KITTITAS COUNTY

MEMORANDUM

TO: Kelly Bacon, CDS
FROM: Zachery Peebles, Engineering Technician I
DATE: October 23, 2019
SUBJECT: BL-19-00021 Lazy Ed Ranch

LAZY ED RANCH SITE PLAN

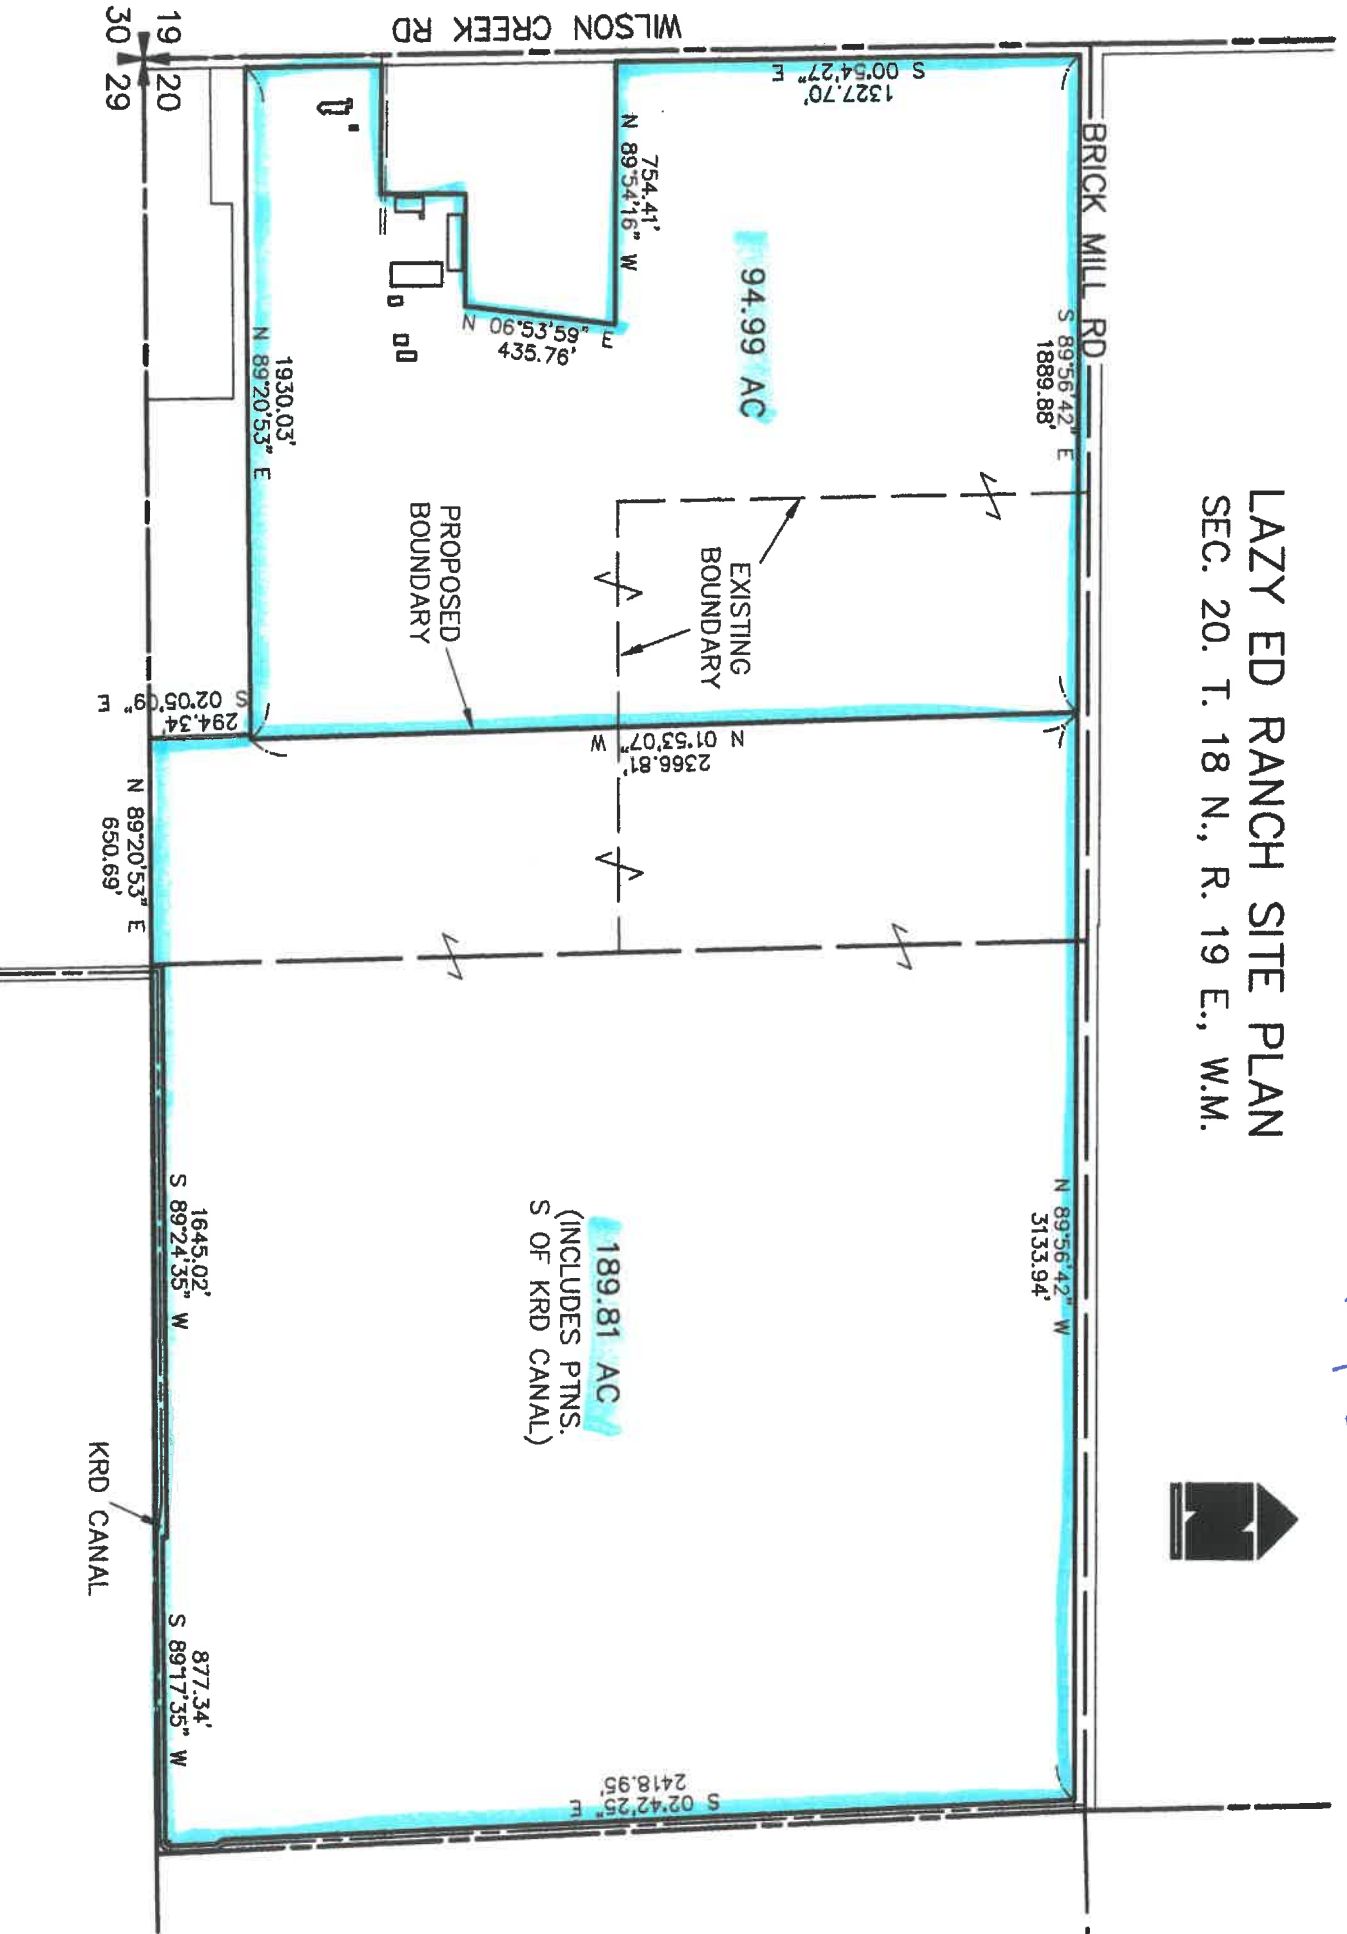
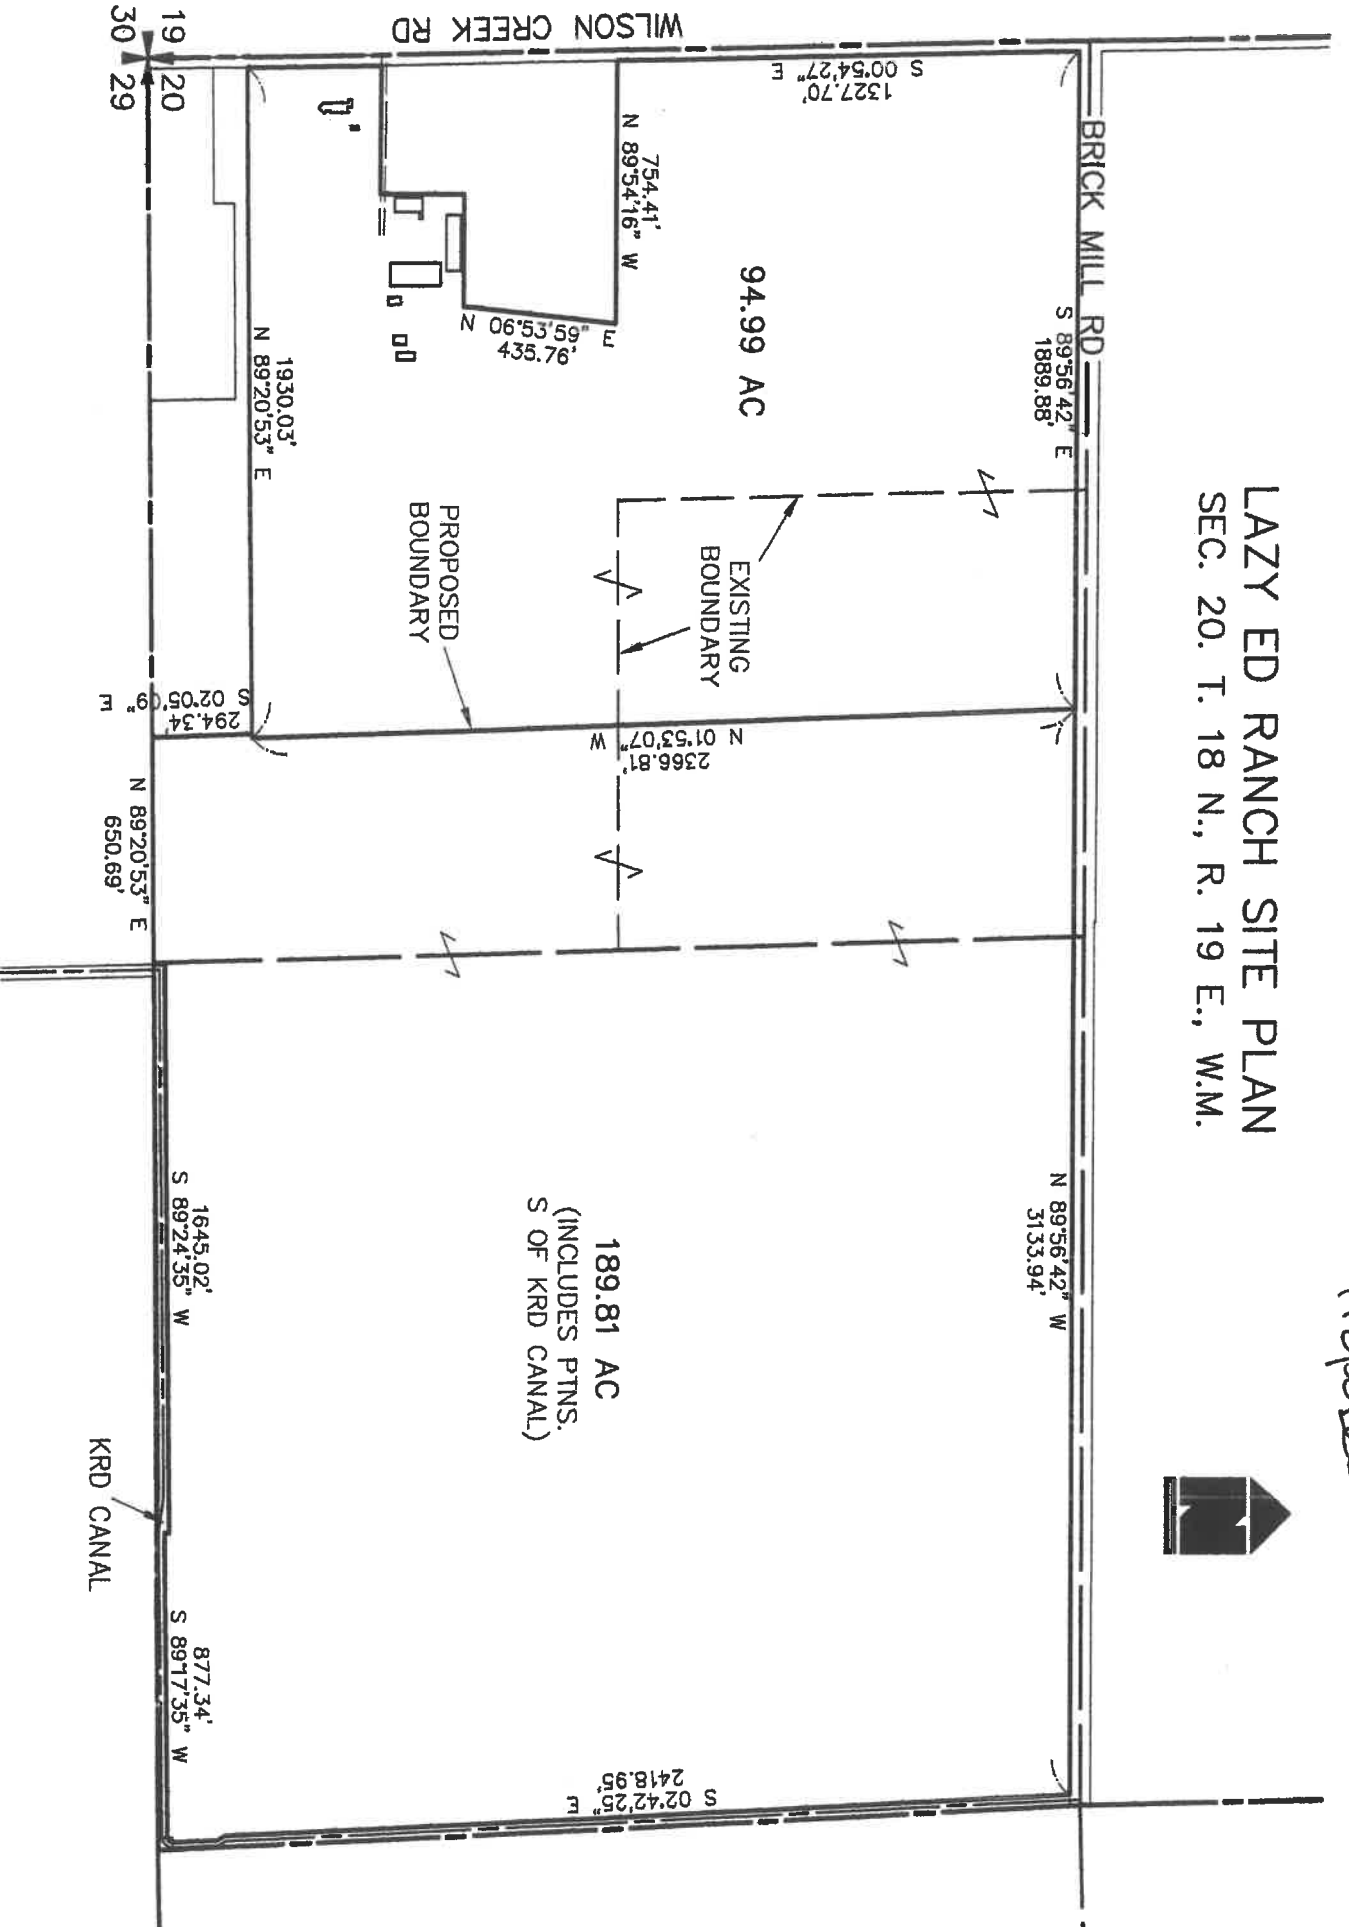
1. A revised legal description that describes the final configuration of the subject property shall be required.
2. A survey map for review
3. Show access easements on the face of the BLA
